## **Landscape and Visual Impact Assessment - Review**

**Dean Moor Solar Farm**

**Cumberland Council**

*Issue: Dean Moor Solar Farm LVIA Review\_FINAL\_170625*

Document Ref: 6.2

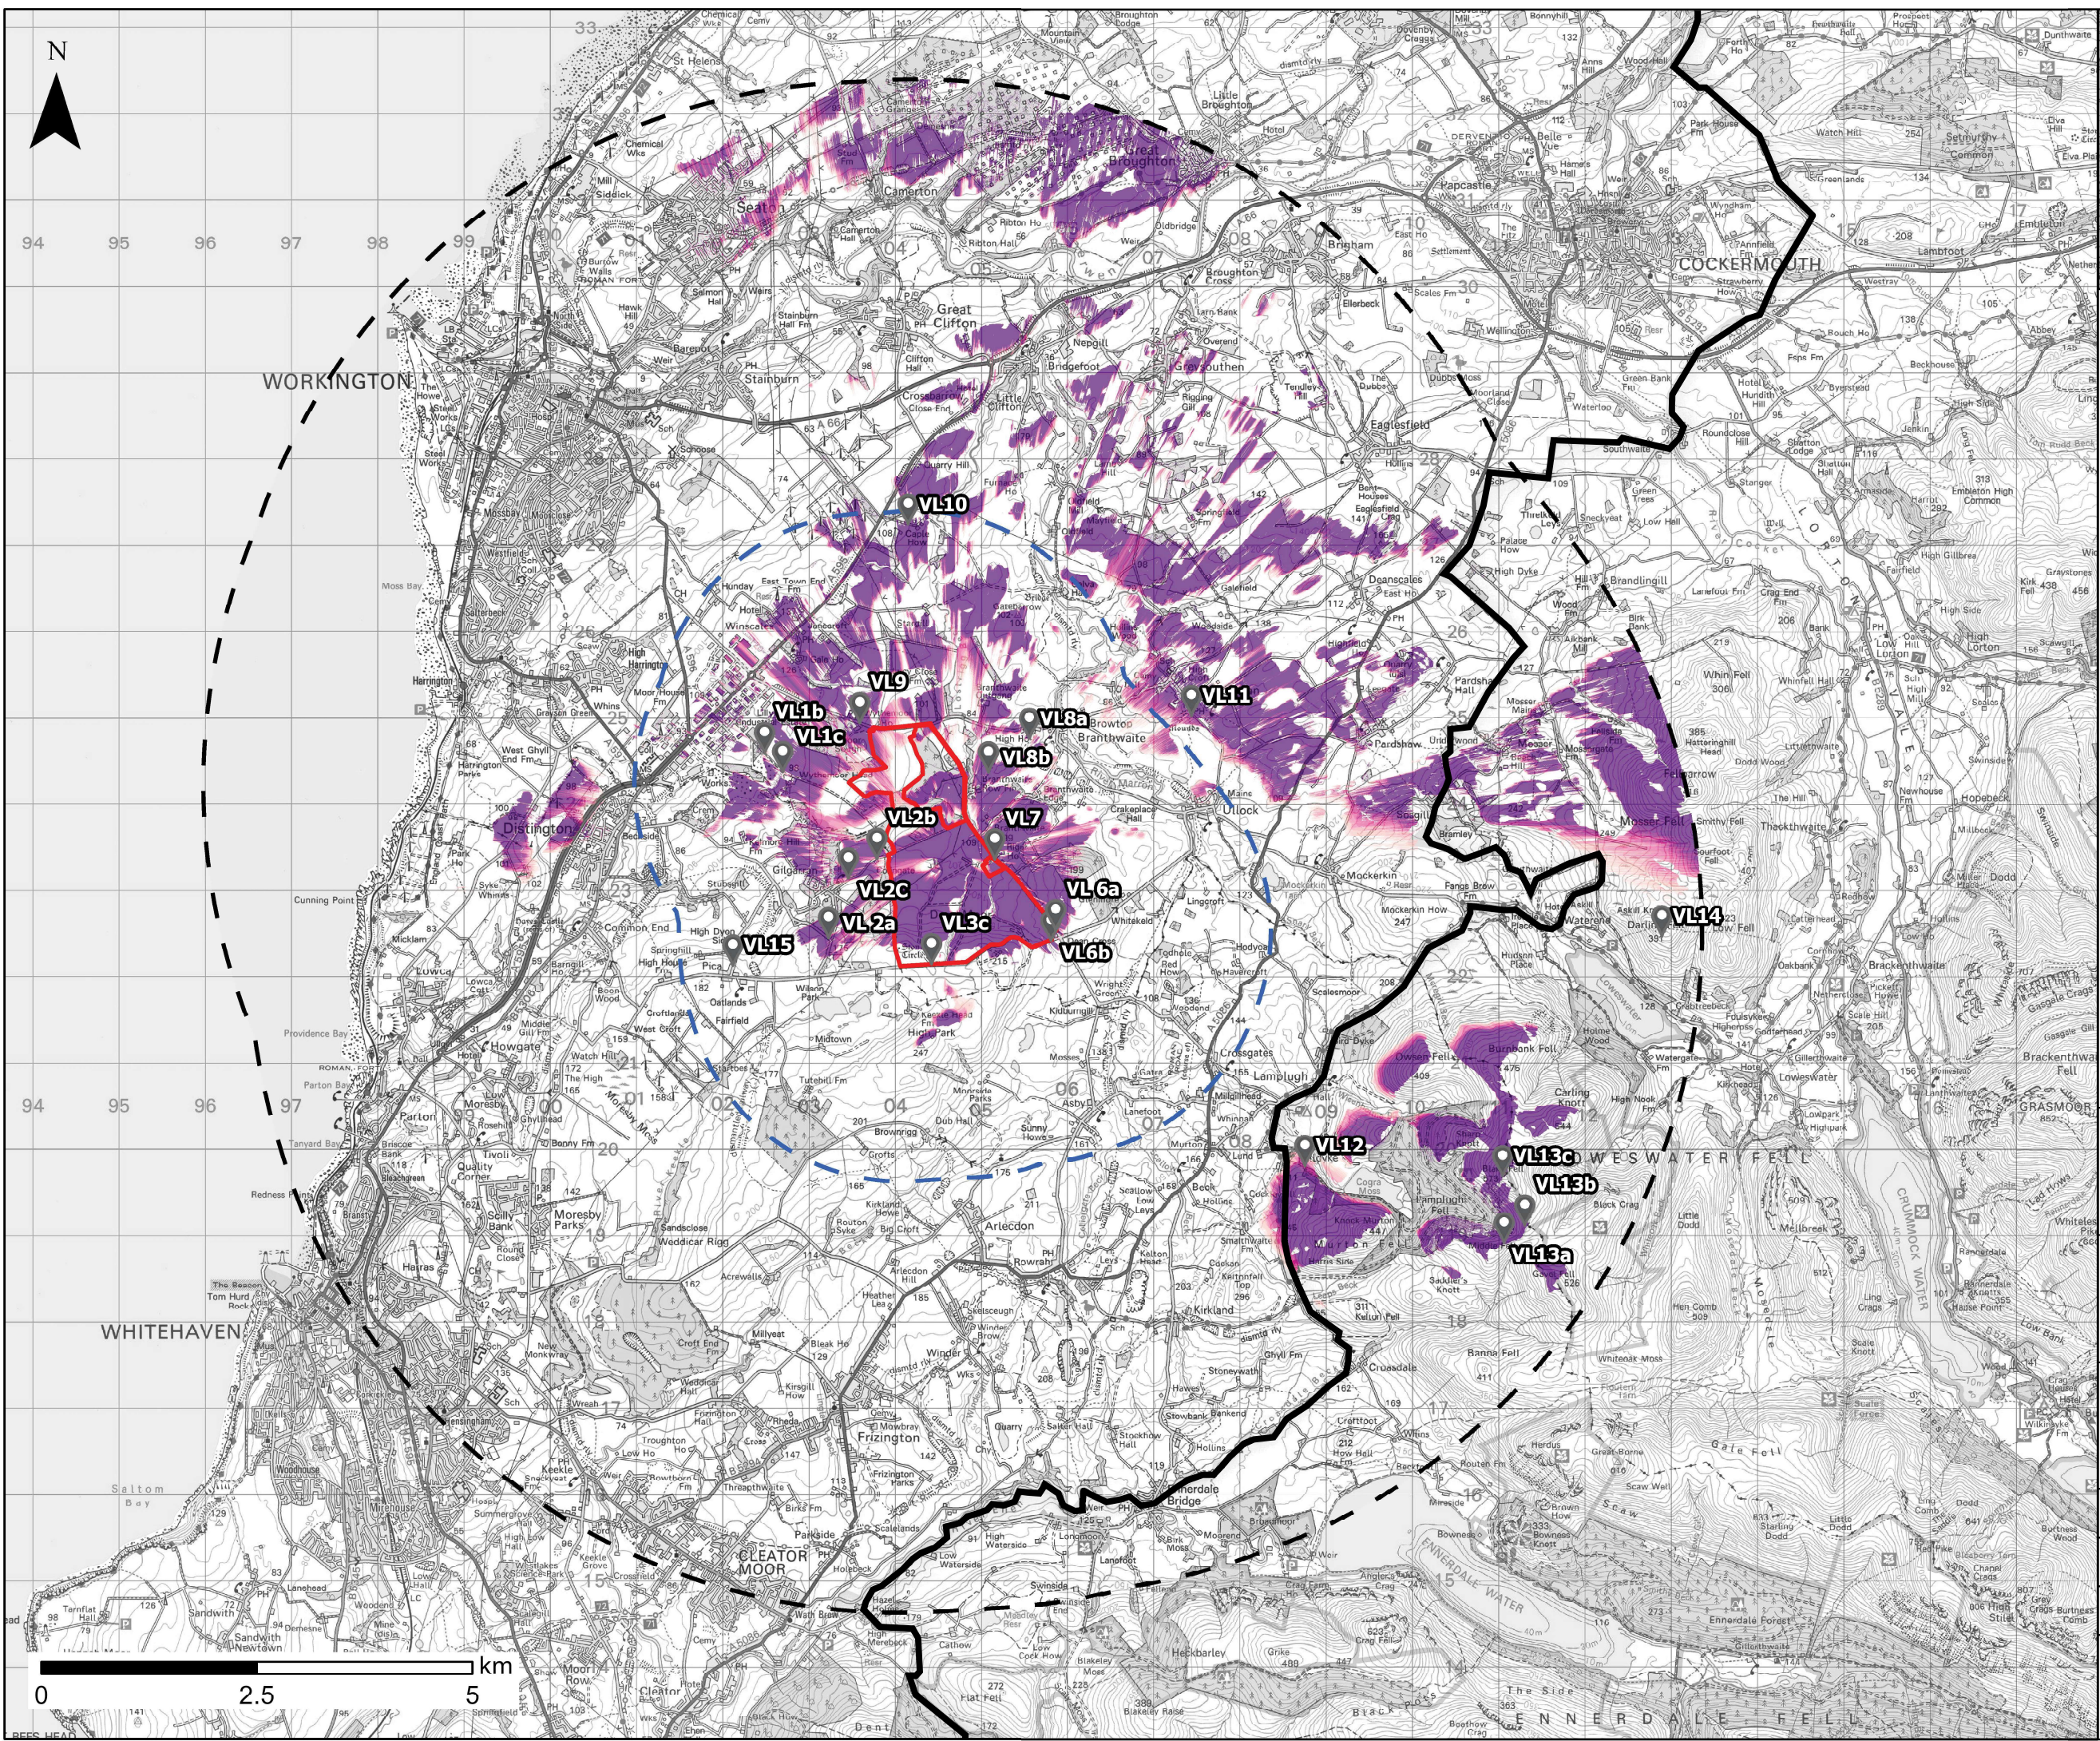
3.3.14	LVIA – Assumptions	<i>'The ES should clearly set out the heights and dimensions of all infrastructure on which the LVIA assessment is based.'</i>	Heights and dimensions of components of the Proposed Development are set out in ES Chapter 3 – Site and Proposed Development Description (Table 3.2). The heights correspond to the heights stated on relevant ZTV plans (Figures 7.4a-b & 7.5a-c).

Environmental Statement: Chapter 7 – Figure 7.6 1-5 Landscape Strategy Plan on behalf of **FVS Dean Moor Limited**

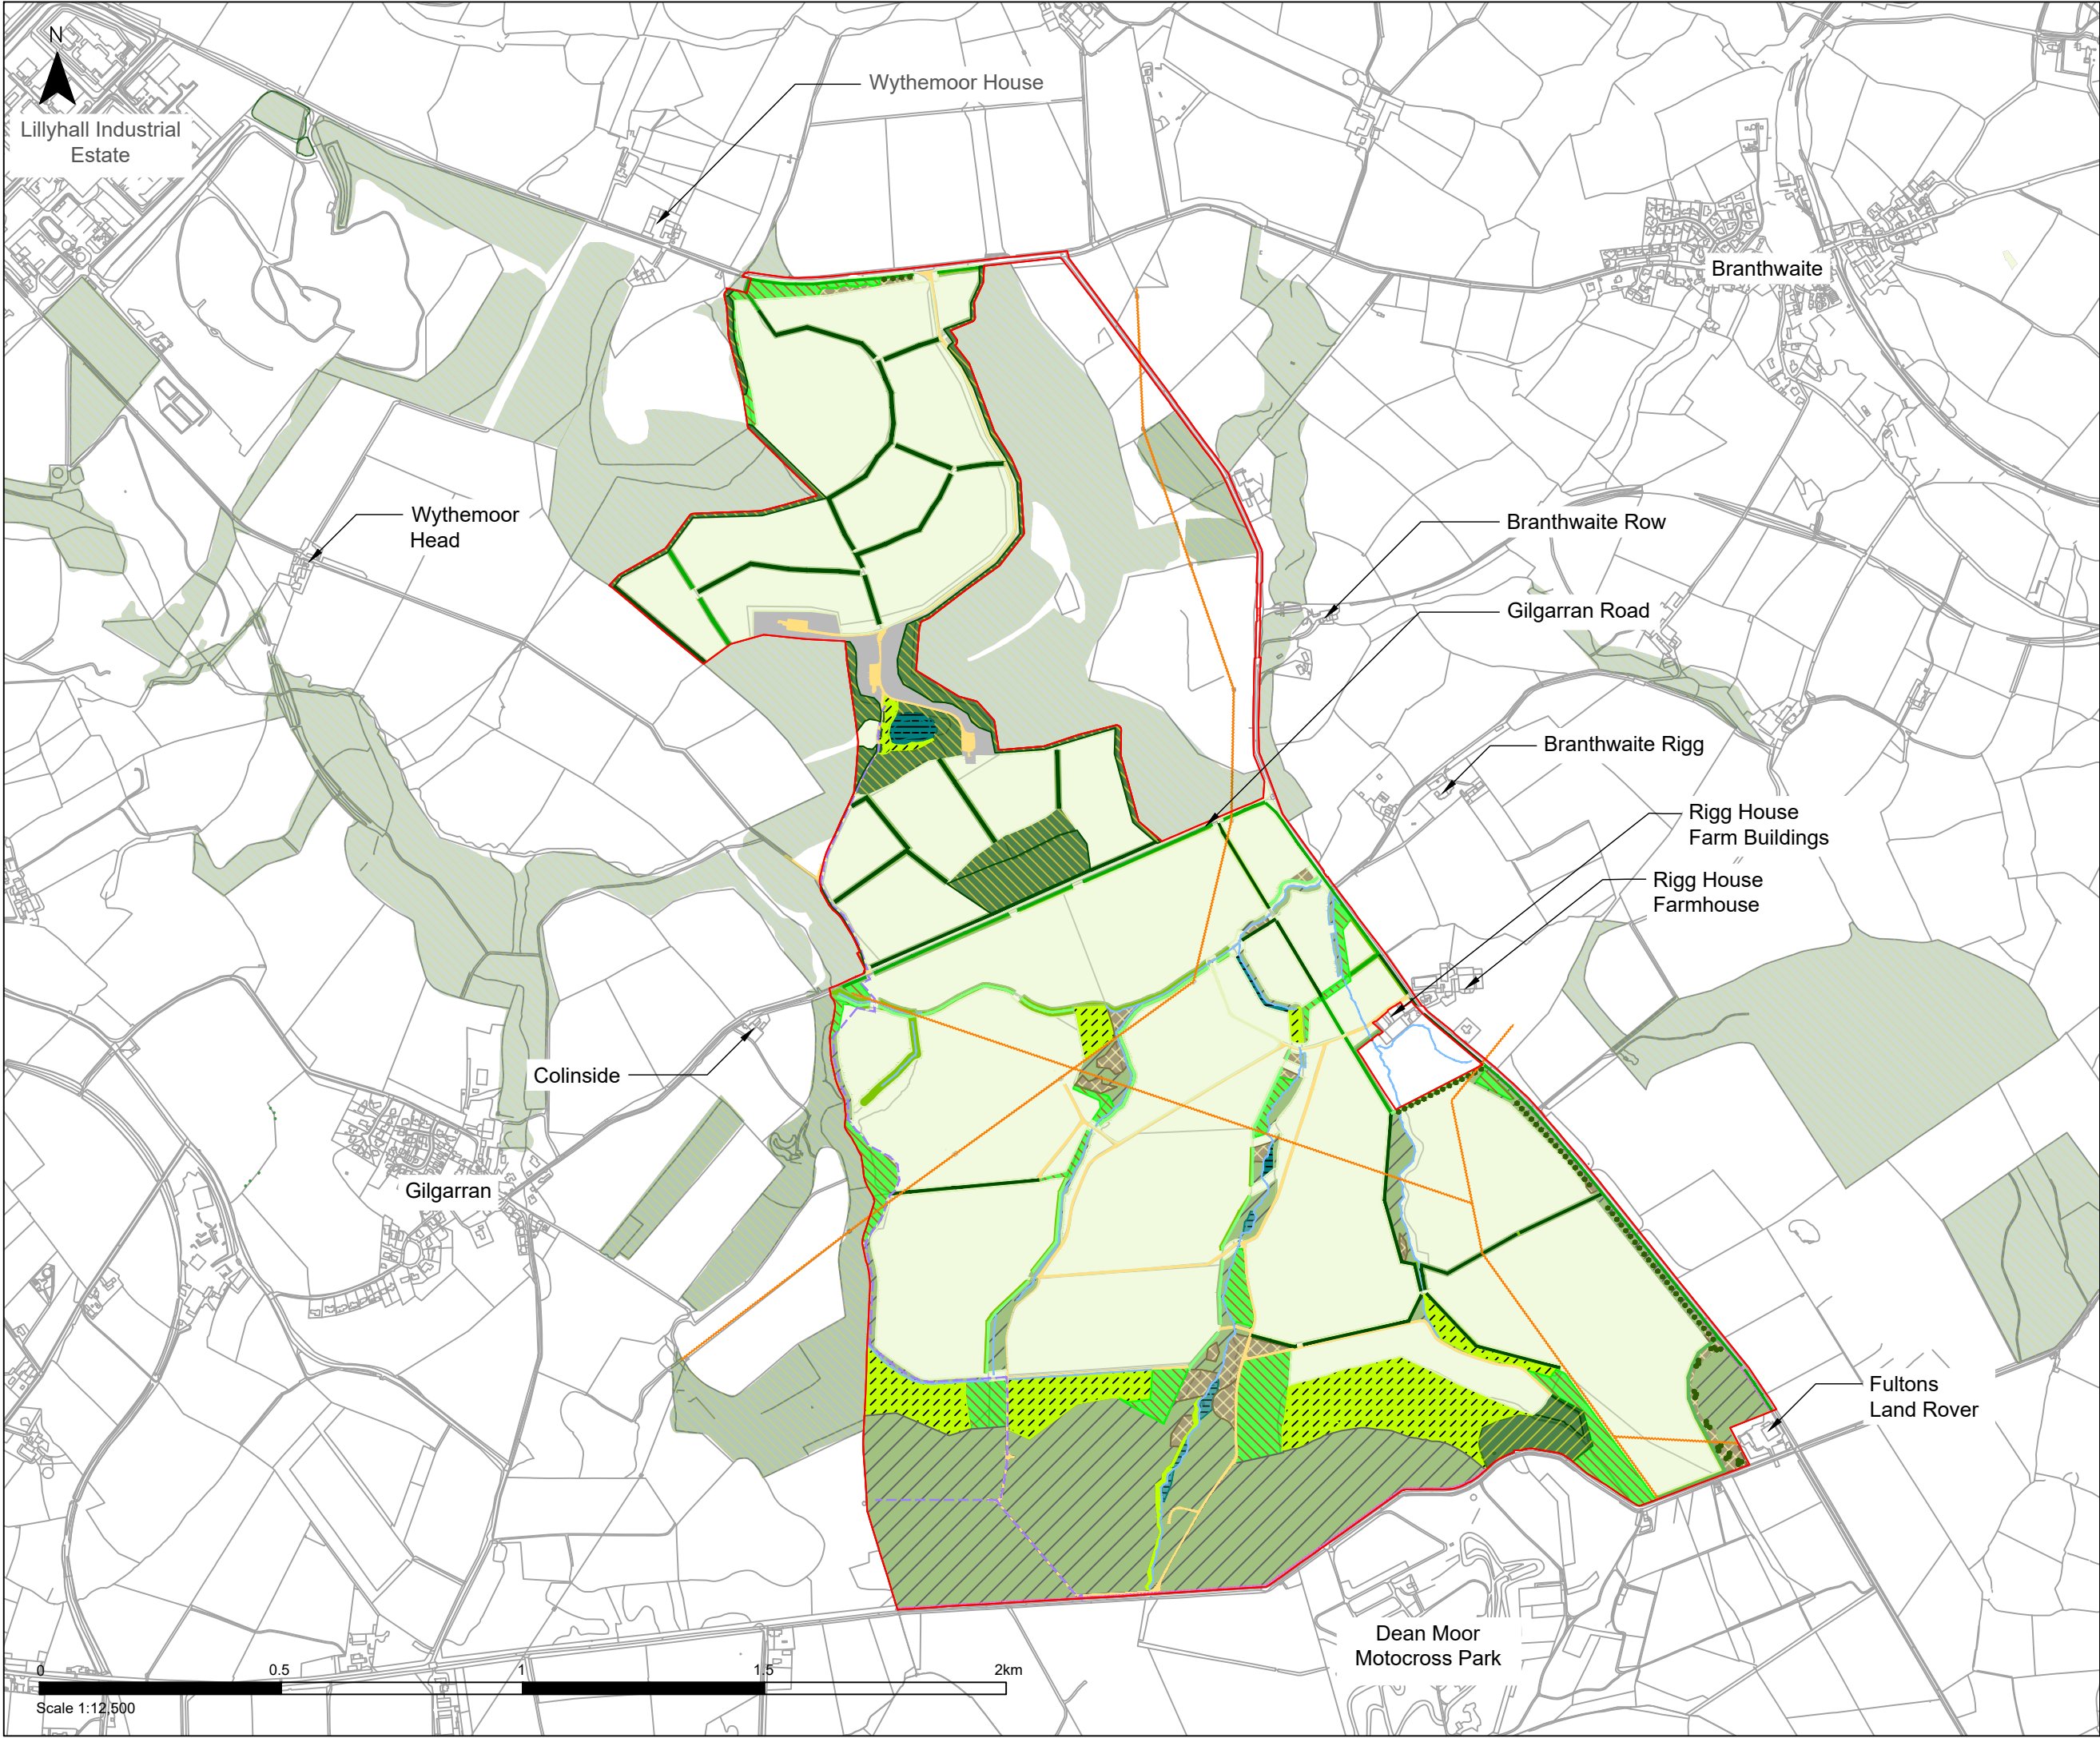
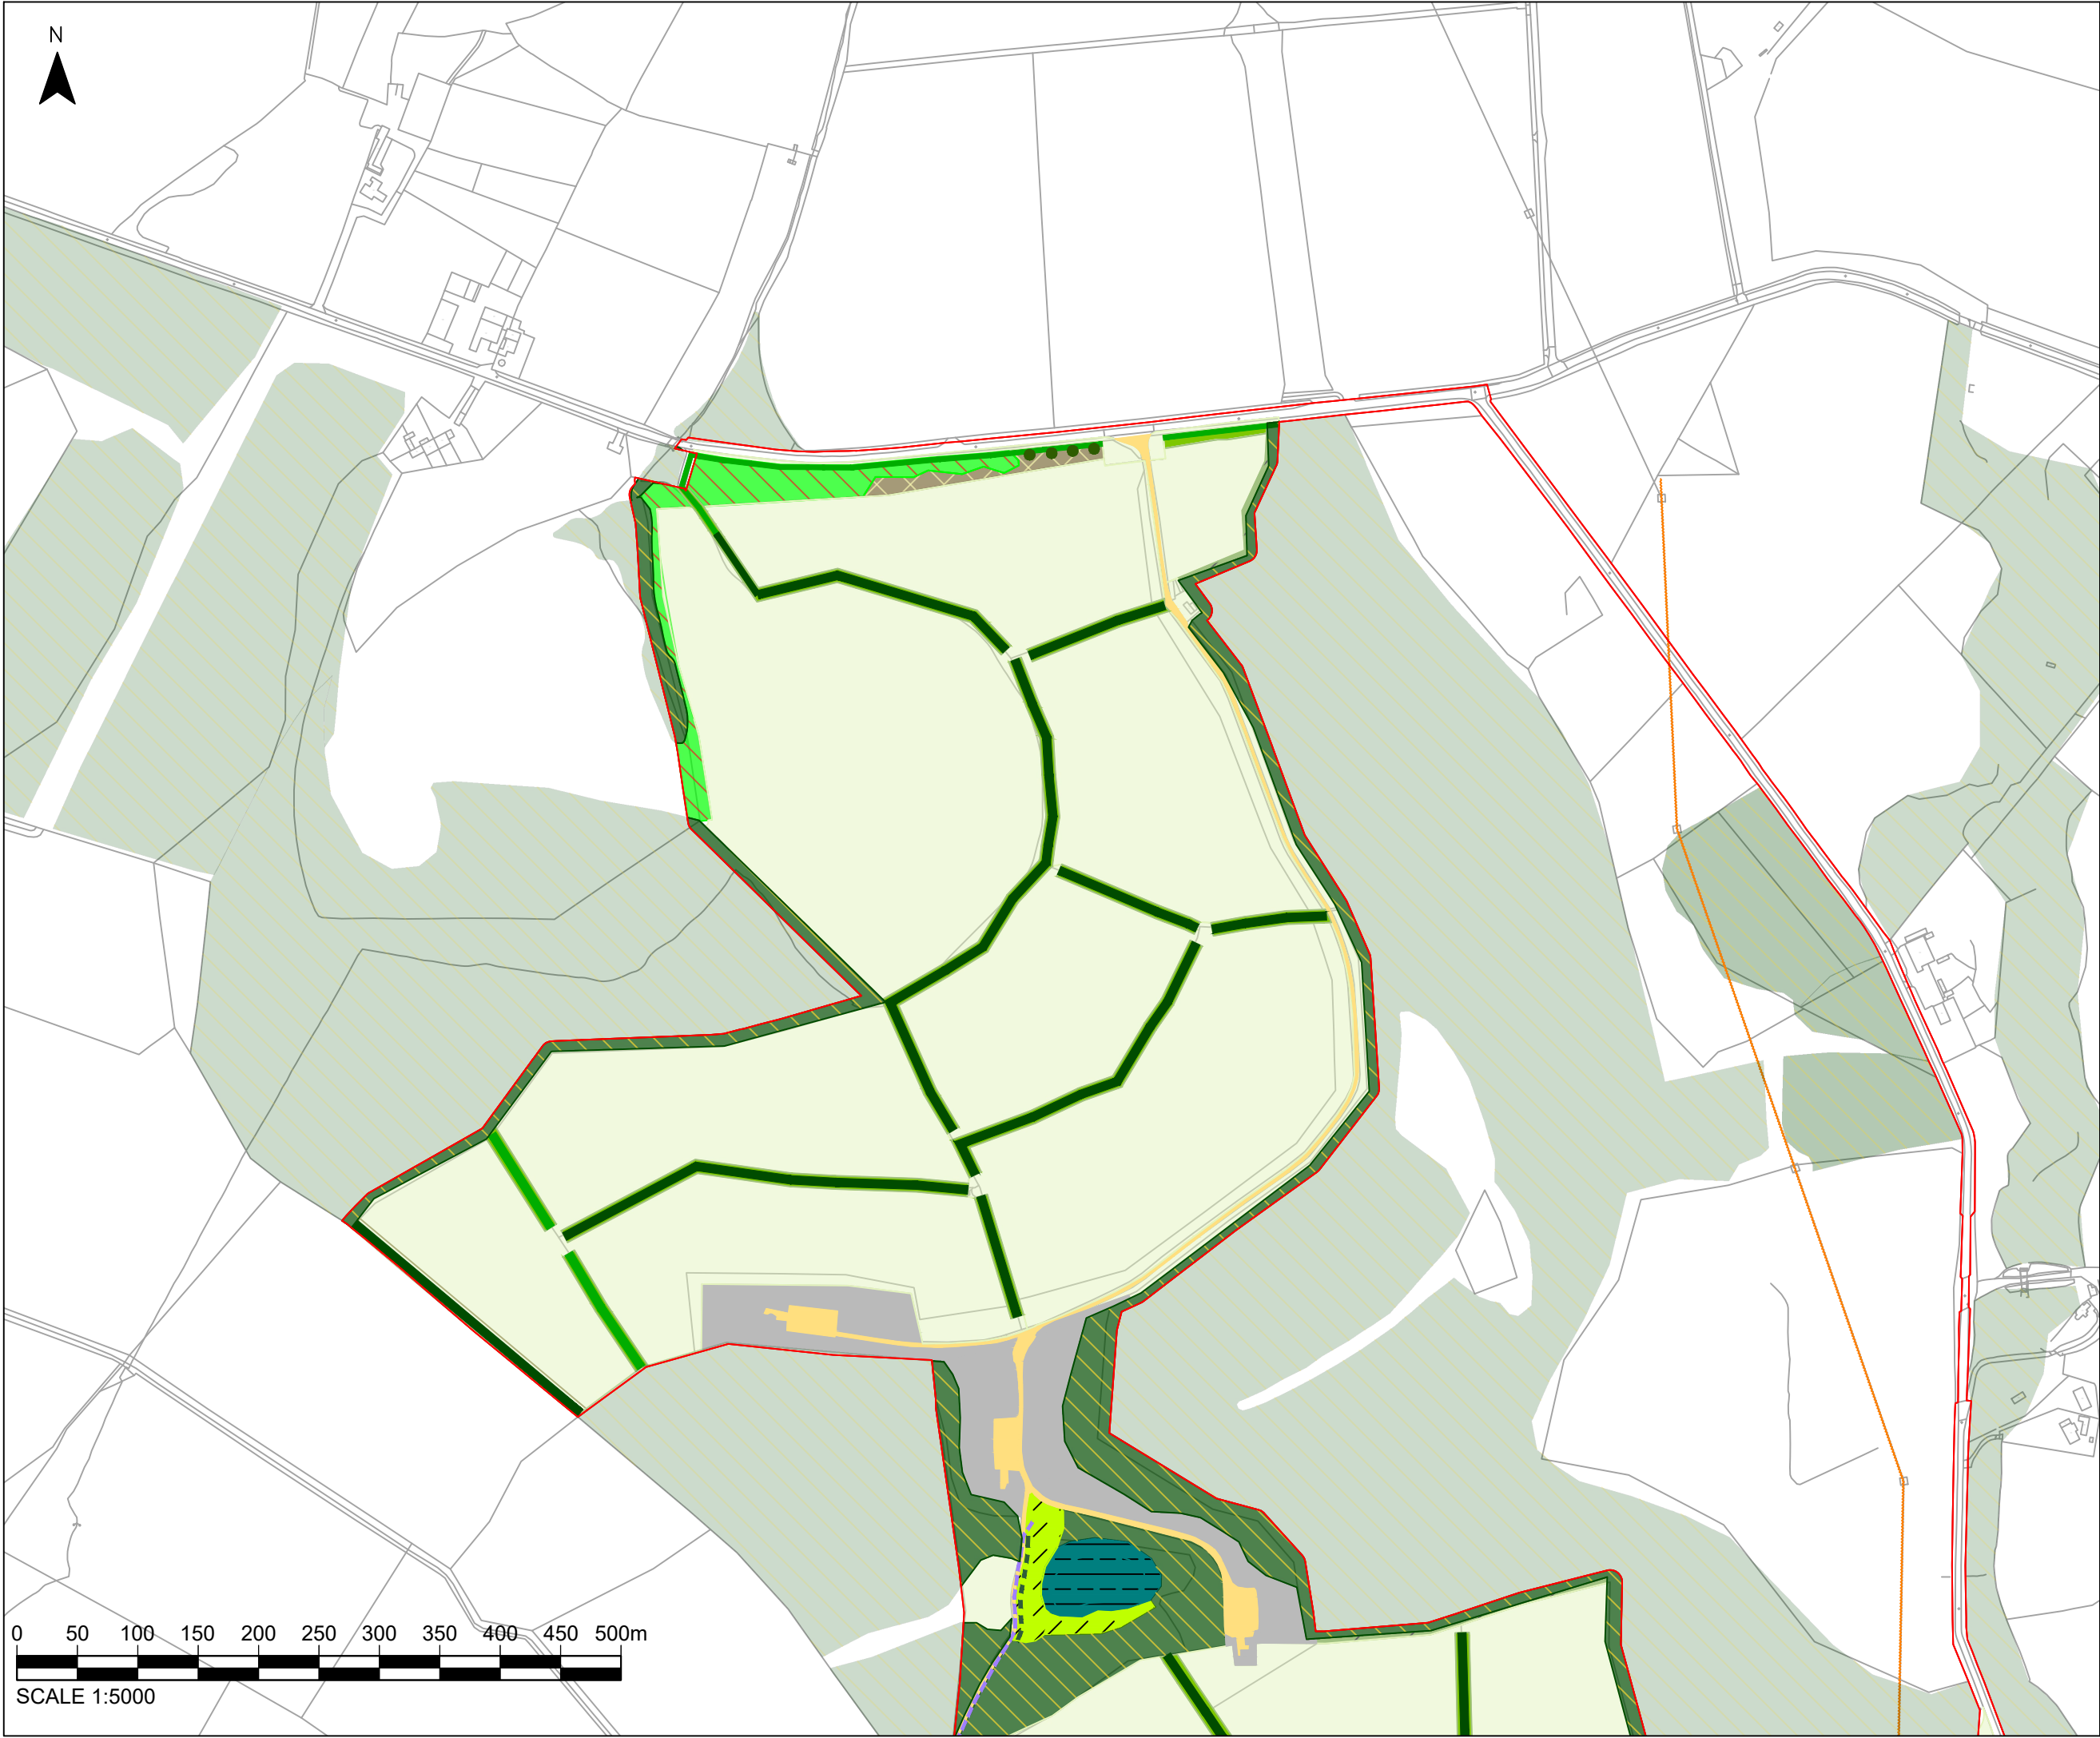
Mitigations proposals are shown in the Landscape Strategy Plan (Figures 7.6.15) and described in para 7.5.3 of the submitted LVIA.

The mitigation measures proposed seek to strengthen the existing landscape features where possible. This includes the infilling and enhancement of existing, enhancing existing woodland and scrub areas as well new woodland planting (along road edges (in the north) and watercourses in the southern area. There is also some hedgerow tree planting along Branthwaite Edge Road on the eastern boundary. These measures would, over time, help to reduce the visibility of the Proposed Development by screening views from the roads which run adjacent to the Site. Further planting of extra woodland and/or hedgerow trees would be suitable along the west of Branthwaite Edge Road.
